Our reference: ECM: 7339715
Contact: Mathew Rawson
Telephone: (02) 4732 7522

Notification of Modification request for PacLib Printing Warehouse and Distribution Facility, Erskine Park (MP08_0016 MOD 5)

WAREHOUSE AND OFFICE FACILITY SITE PLAN

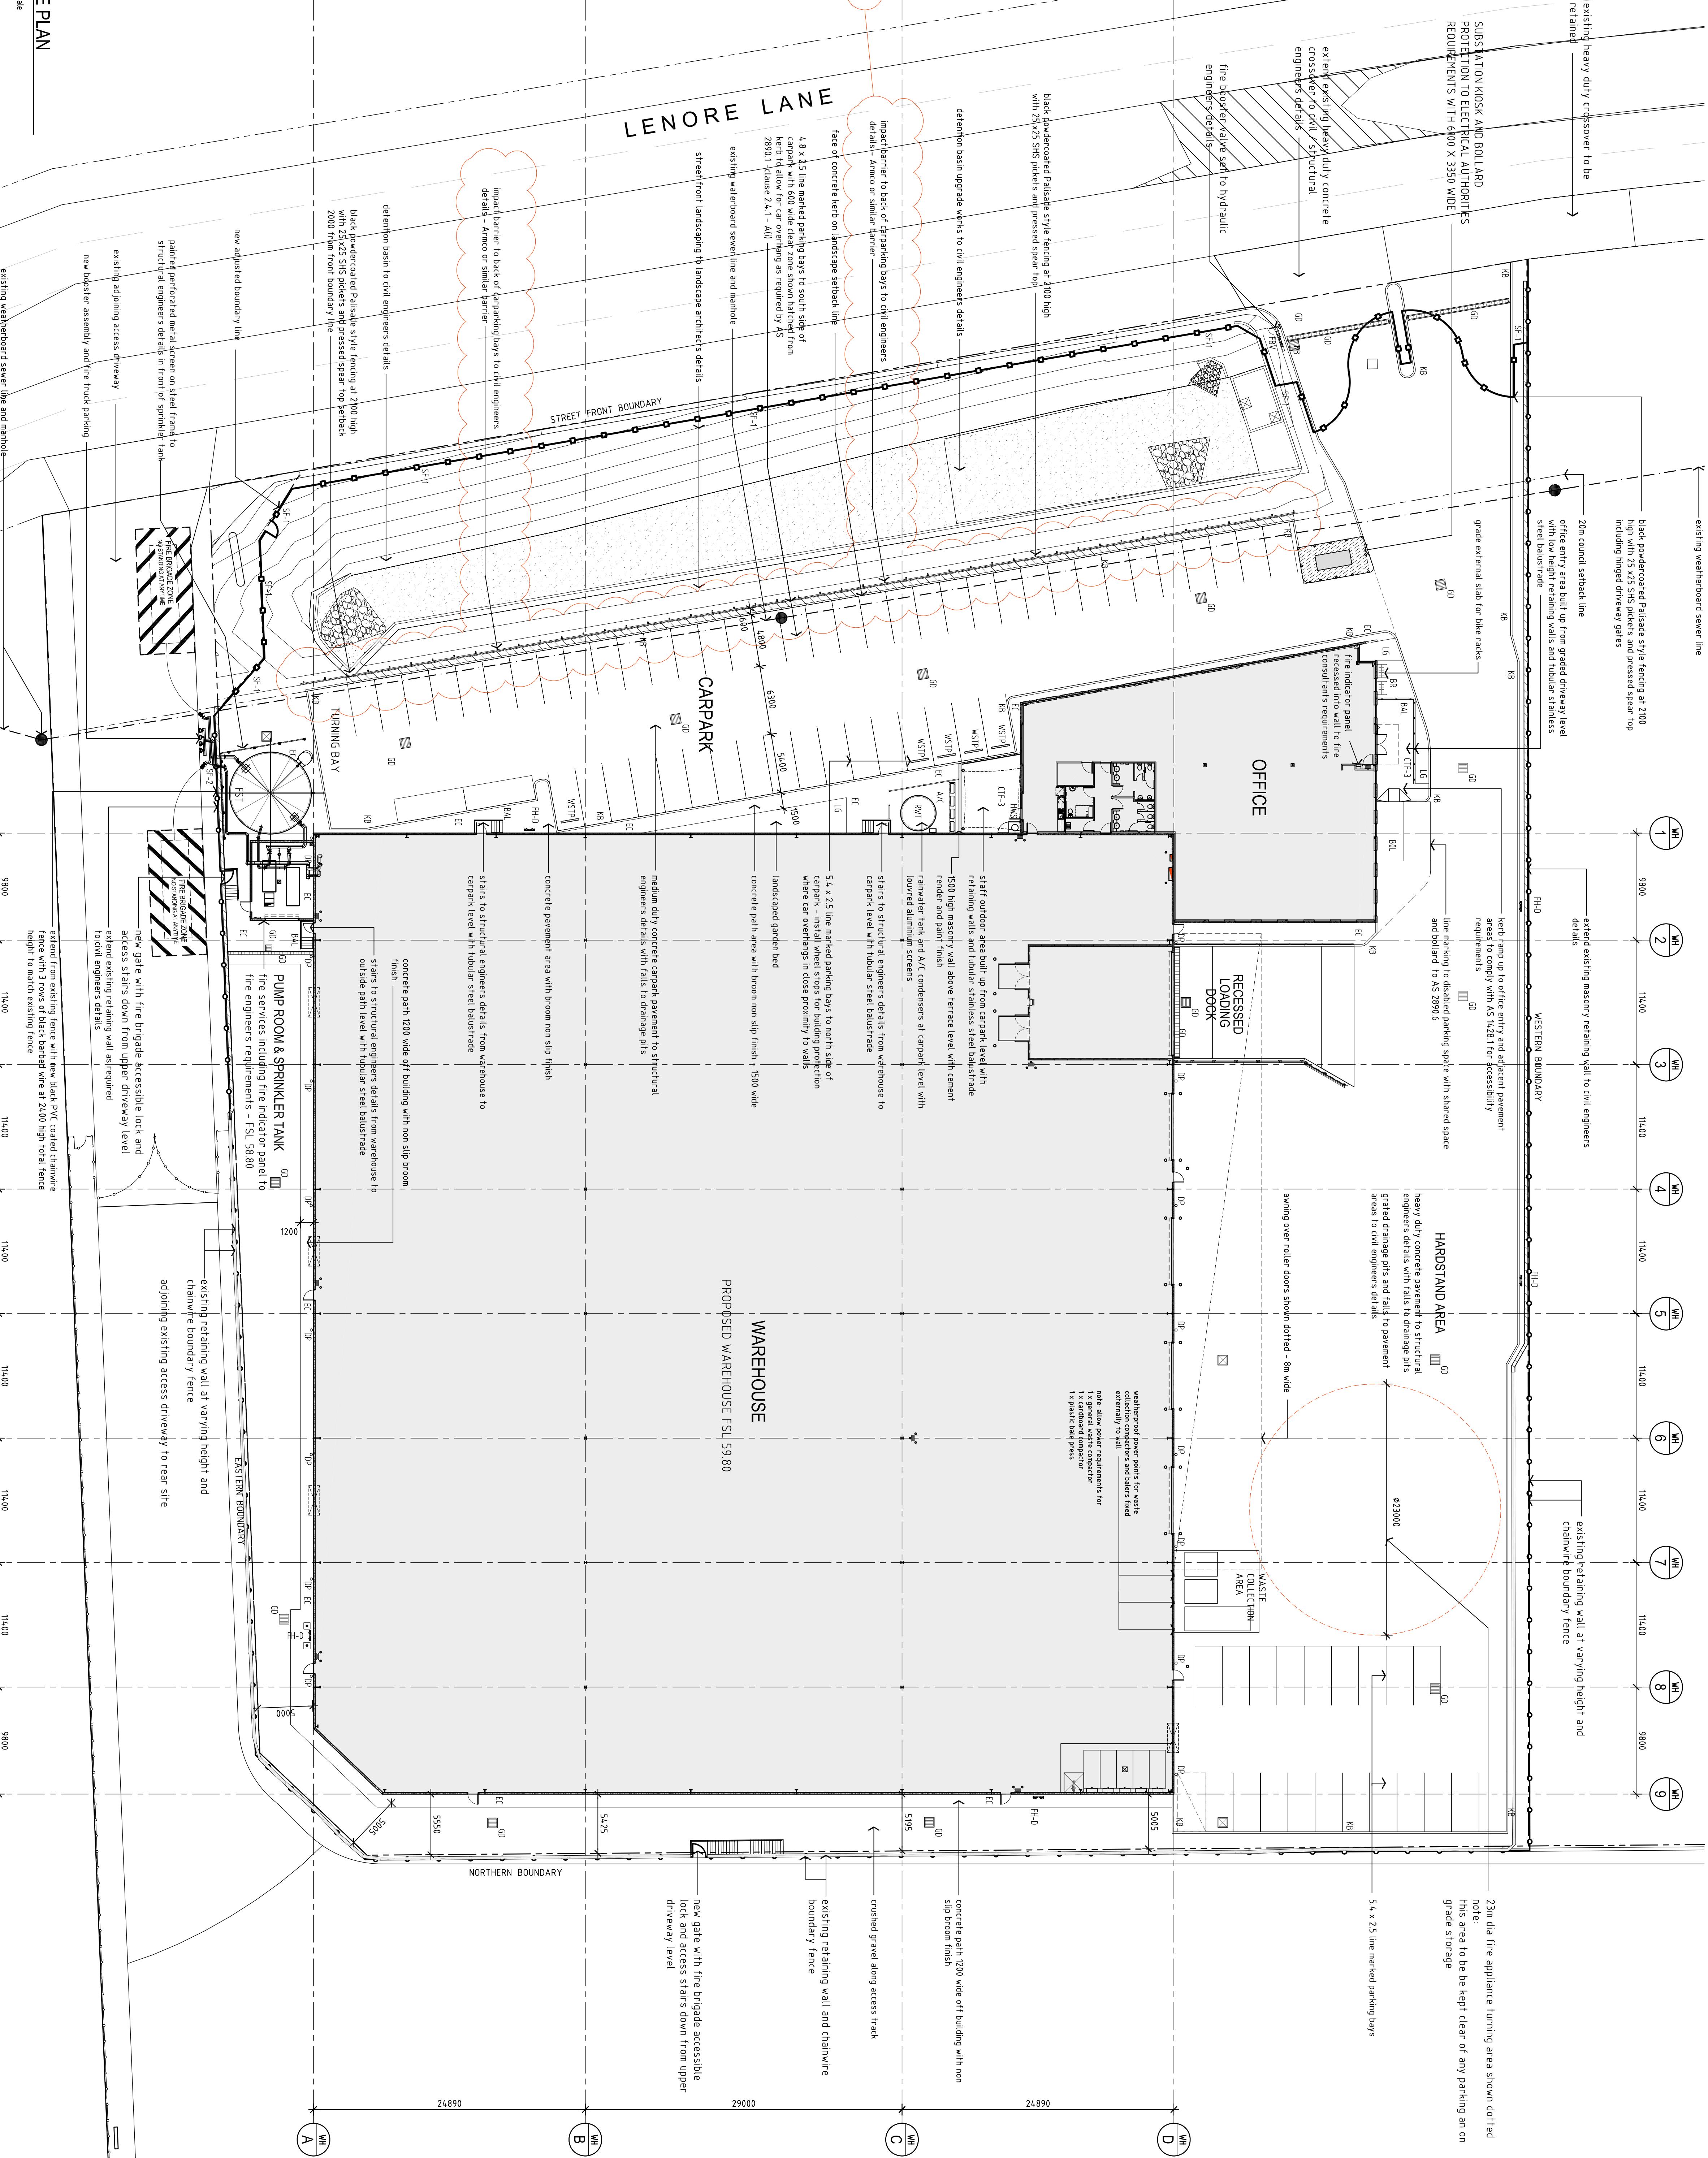
It is still Council's preference that site fencing in the Erskine Business Park be situated behind a landscaped strip at the front of the site, rather than along the front boundary given the cumulative visual impact of such fencing. However in this instance it is noted that there is a large detention basin proposed within the landscape setback. Additionally it is noted that the establishment of fencing between the basin and public domain is necessary to ensure a safe outcome for the community.

As a result no further objections are raised to the proposal.
